Our Case Number: ABP-317809-23

Re: Proposed Coolglass windfarm and related works
In the townlands of Fossy Upper, Aghoney, Gorreelagh, Knocklead, Scotland, Brennanshill,
Monamantry, Coolglass, Crissard and Kilenabehy, Co. Laois.

Case Reference: PA11.317809

Proposed Coolglass Windfarm and related works

Figure 7-13 Bare-ground Zone of Theoretical Visibility (ZTV) Map

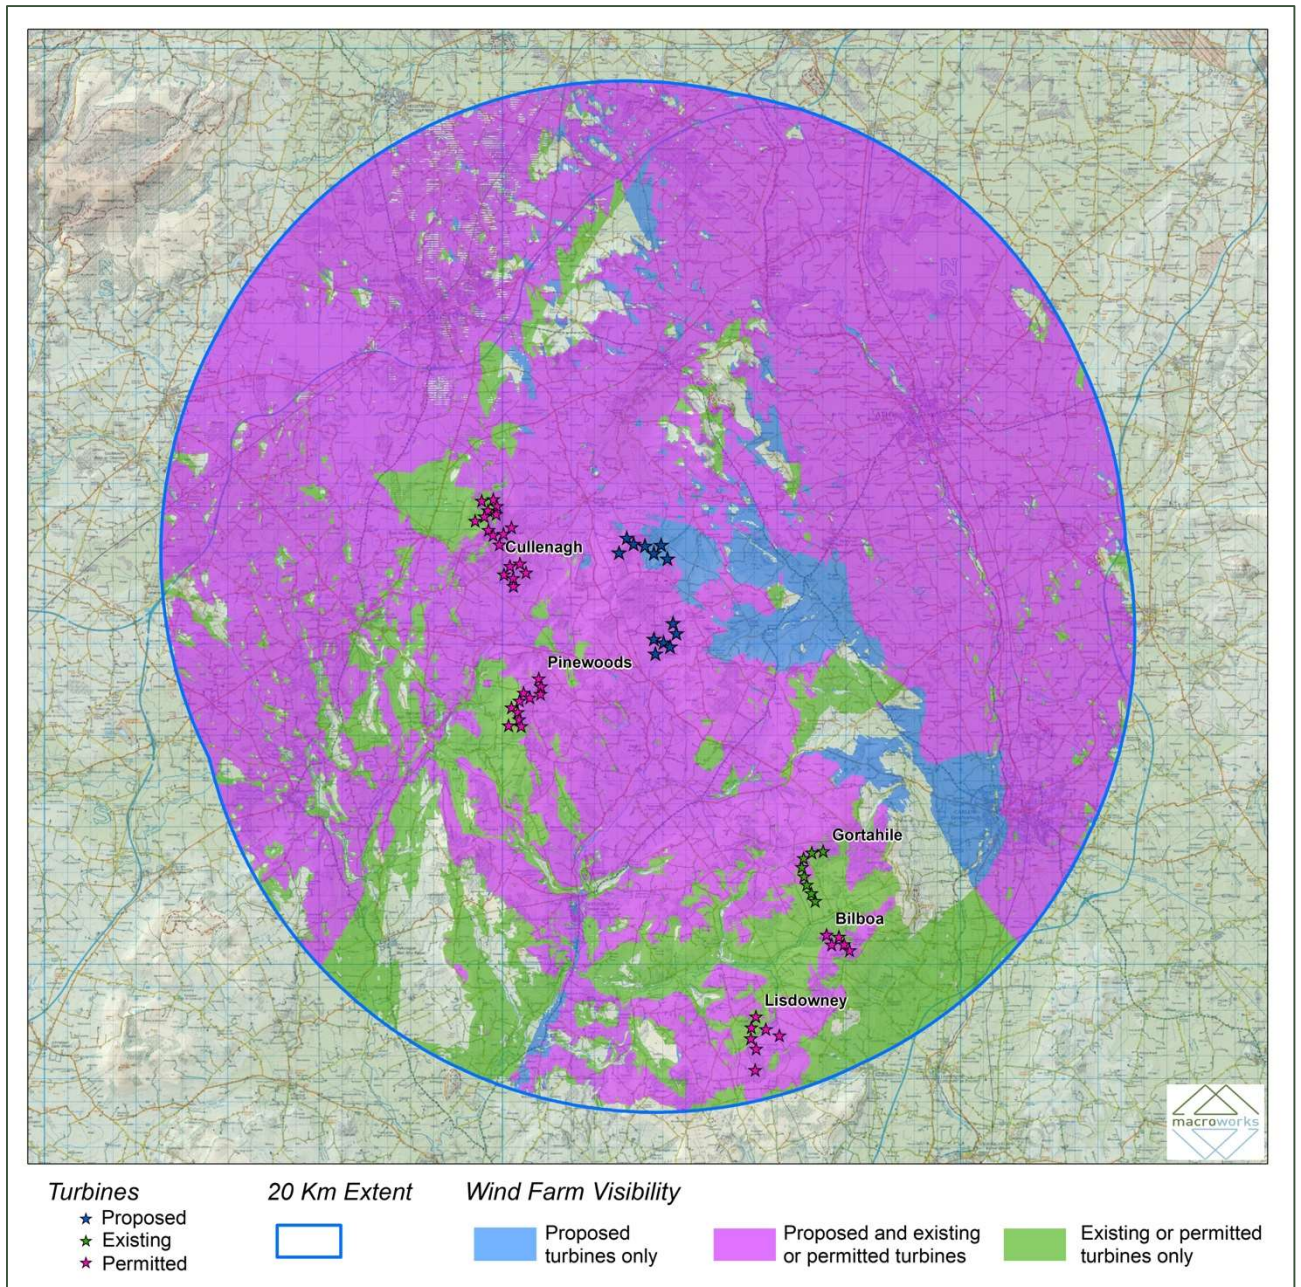
The Bord needs to regard the cumulative effects of both sites of this proposed windfarm on Fossy Mountain and Wolfhill named by the developer as 'Coolglass Windfarm', combined with the following projects which have already secured planning permission.

The Bord must consider the cumulative effects of this proposed development along with the other granted developments mentioned above, all of which are within a 10km radius of the subject development. The Bord must consider the visual impact on the rural scenic landscape close to the Heritage village of Timahoe and the rural scenic uplands of the Coolglass, Aghadreen, Moyad, Scotland, Wolfhill, and Slatt areas. The proposed development alone would form a visually obtrusive feature in the landscape and negatively impact the nationally significant archaeological, heritage sites and sacred spaces. (2003_ Unesco Convention for the Safeguarding of the Intangible Heritage) and (European Convention on the Protection of the Archaeological Heritage).

Figure 10.14: Noise Limits at NML1 According to 2006 Guidelines

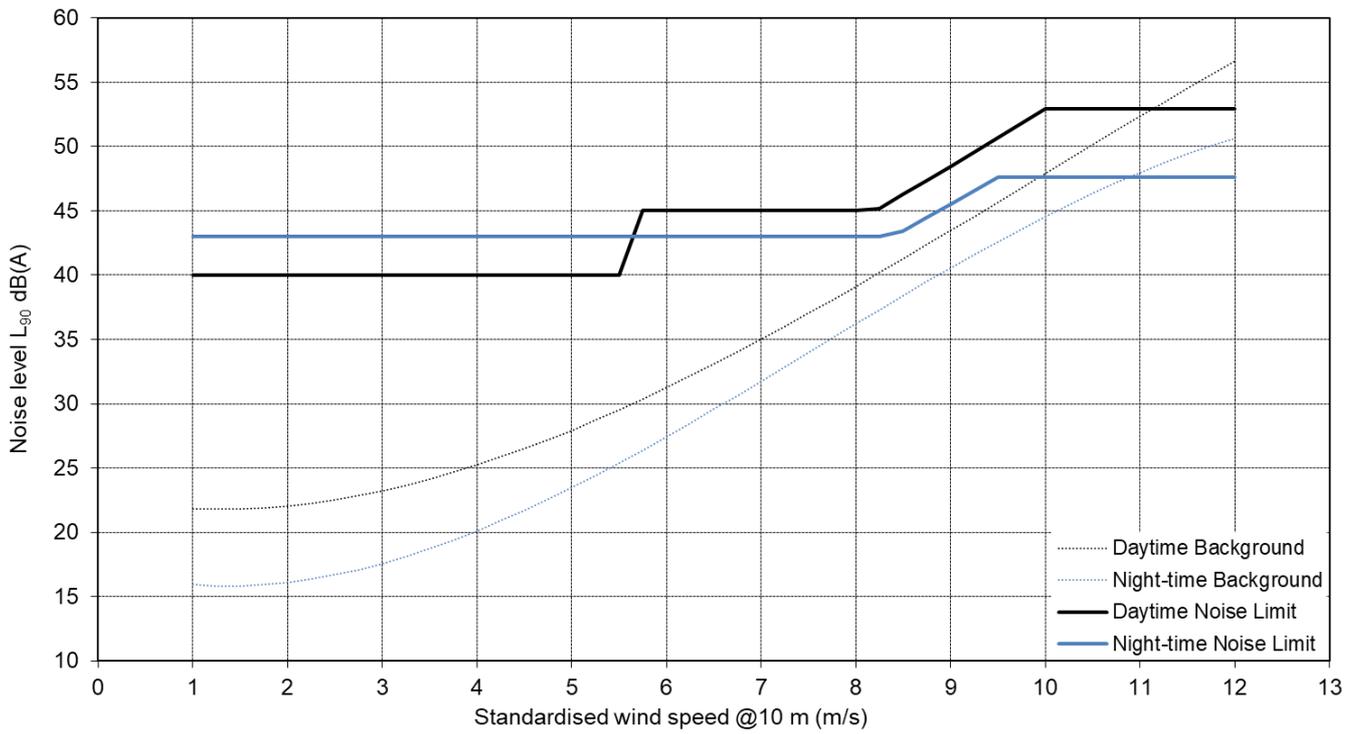
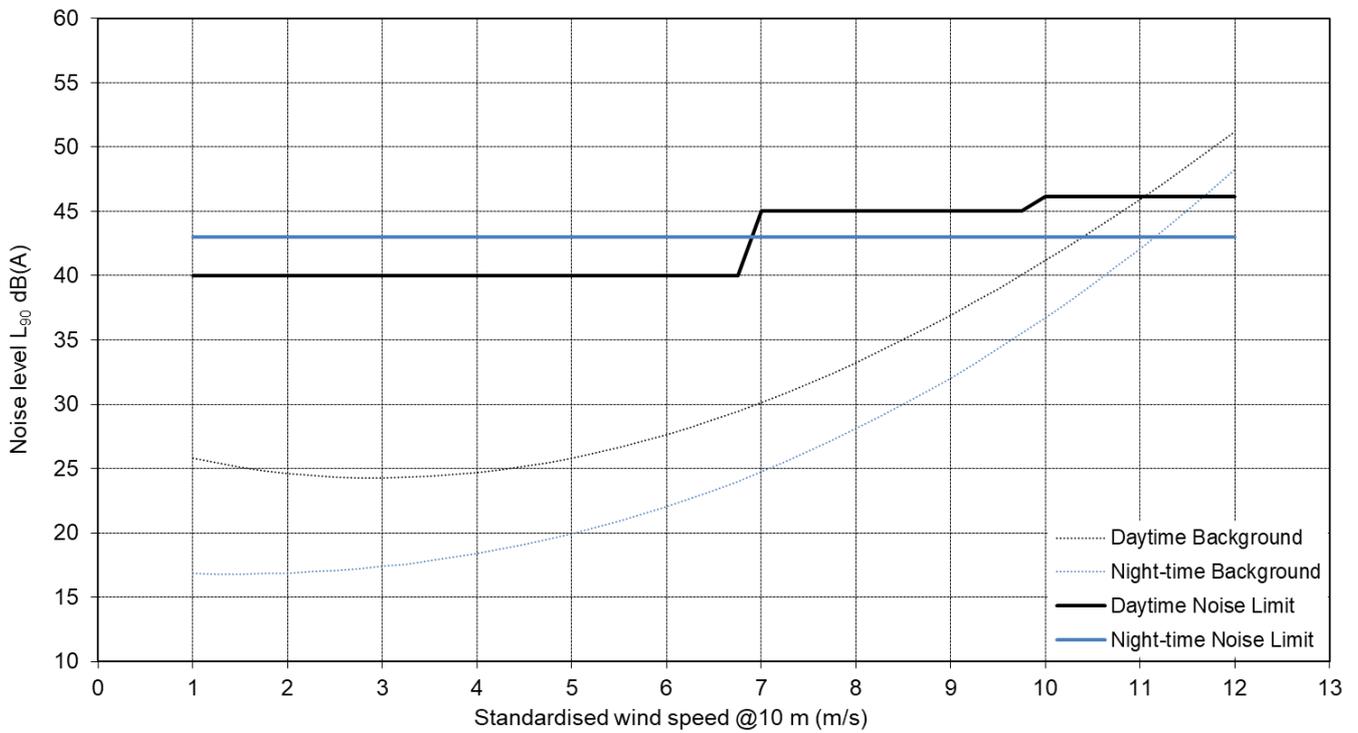
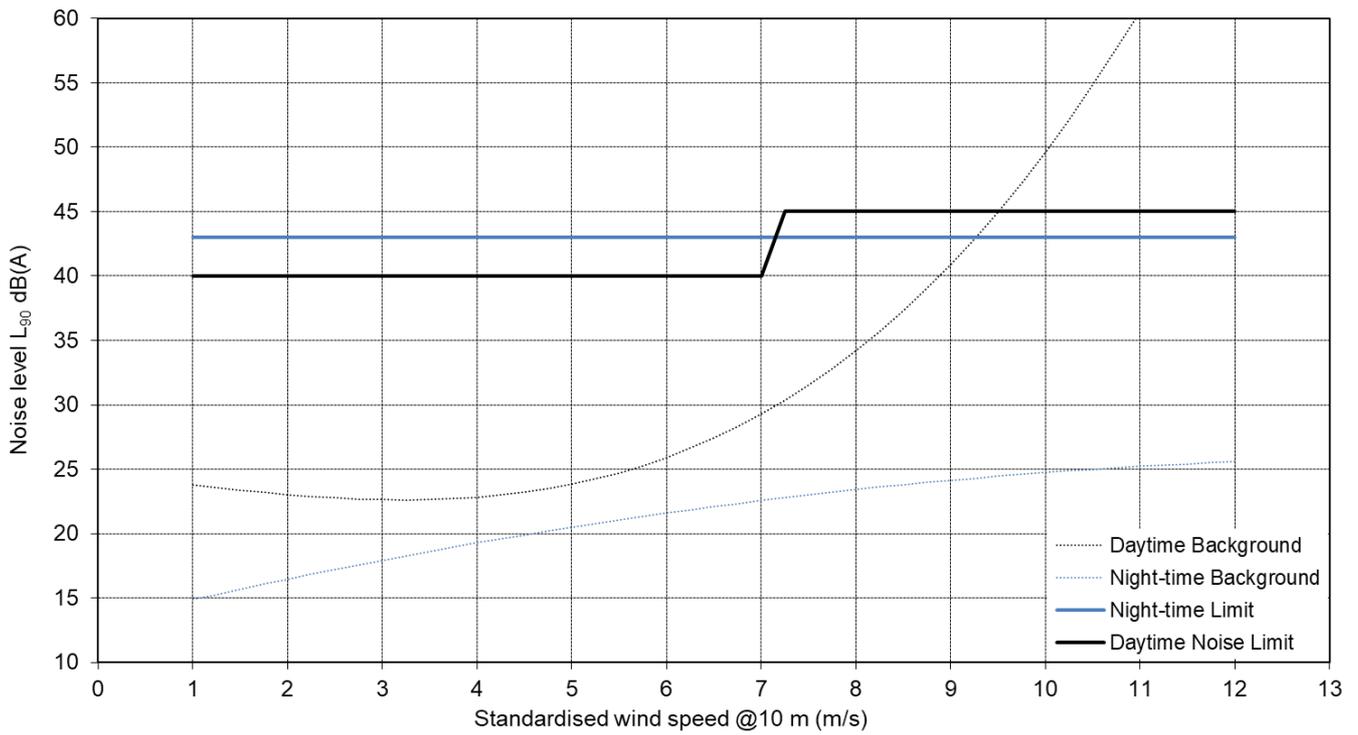
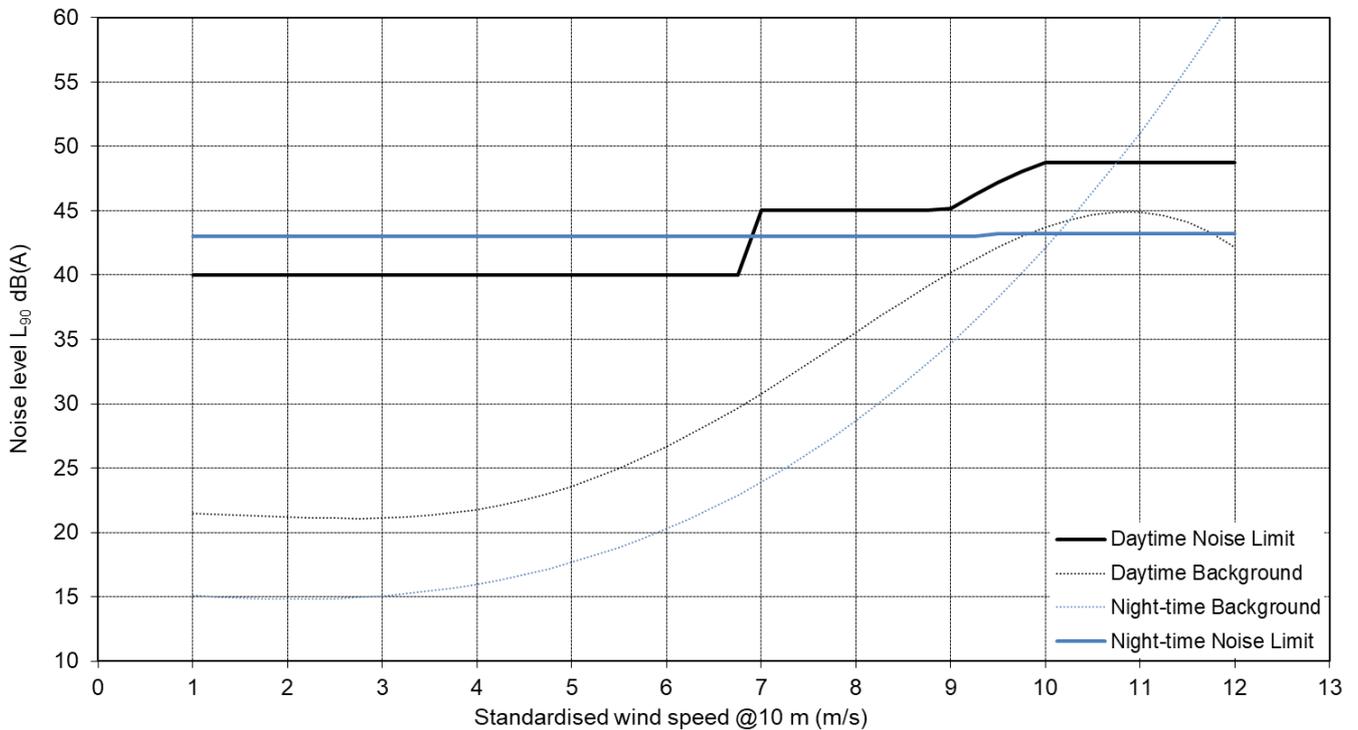
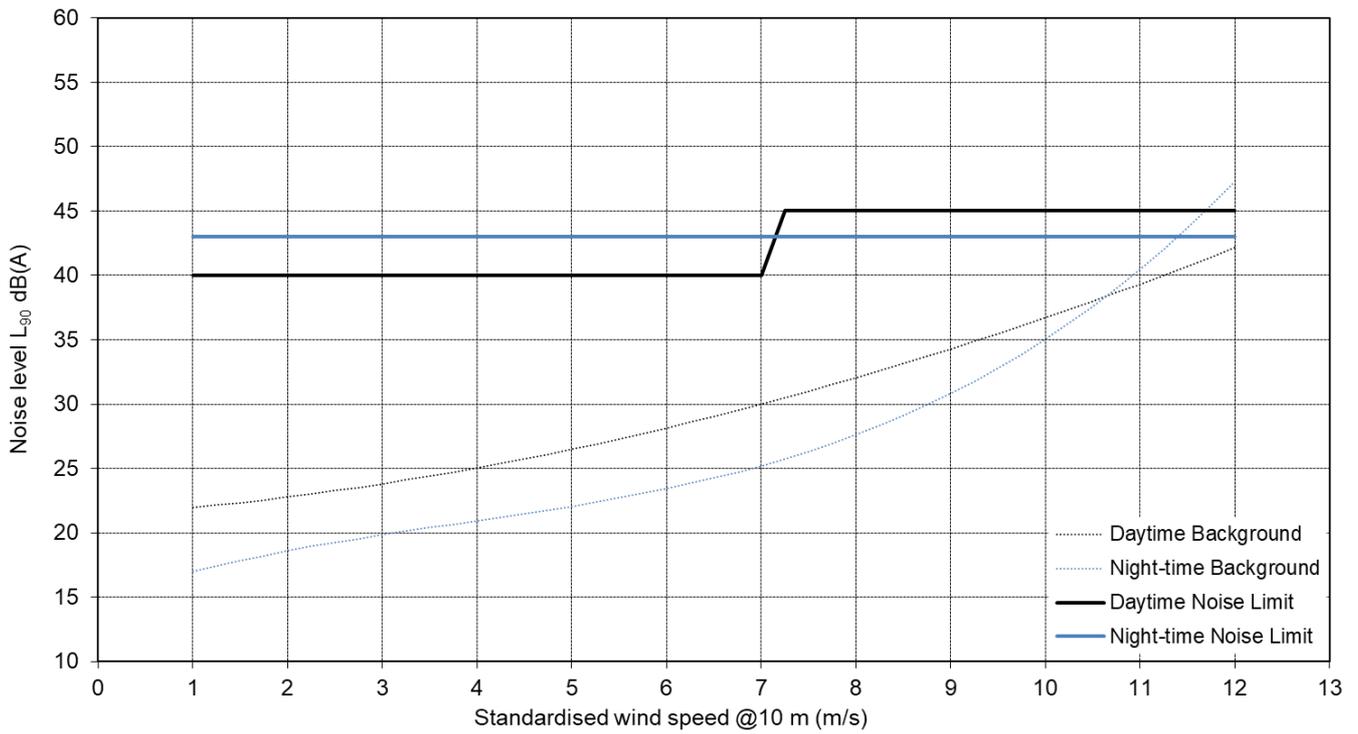
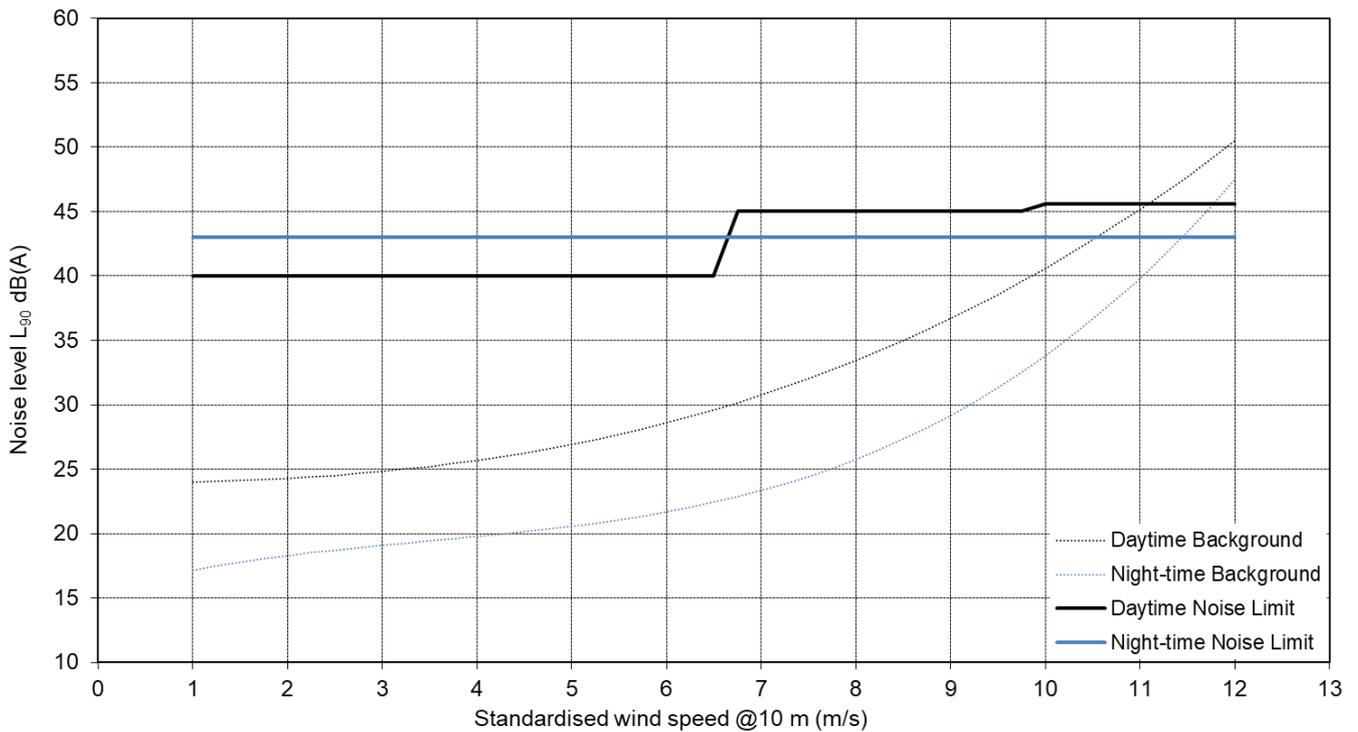
The developer cannot mitigate against the noise of a 180mtr turbine with a setback distance of approximately 700mtrs to the nearest homes. The developer cannot realistically mitigate how the uphill/downhill gradient will treat the noise from turbines of this measure and what effect it will have on the nearest homes. This development is too close to the homes of local people for turbines of this scale.
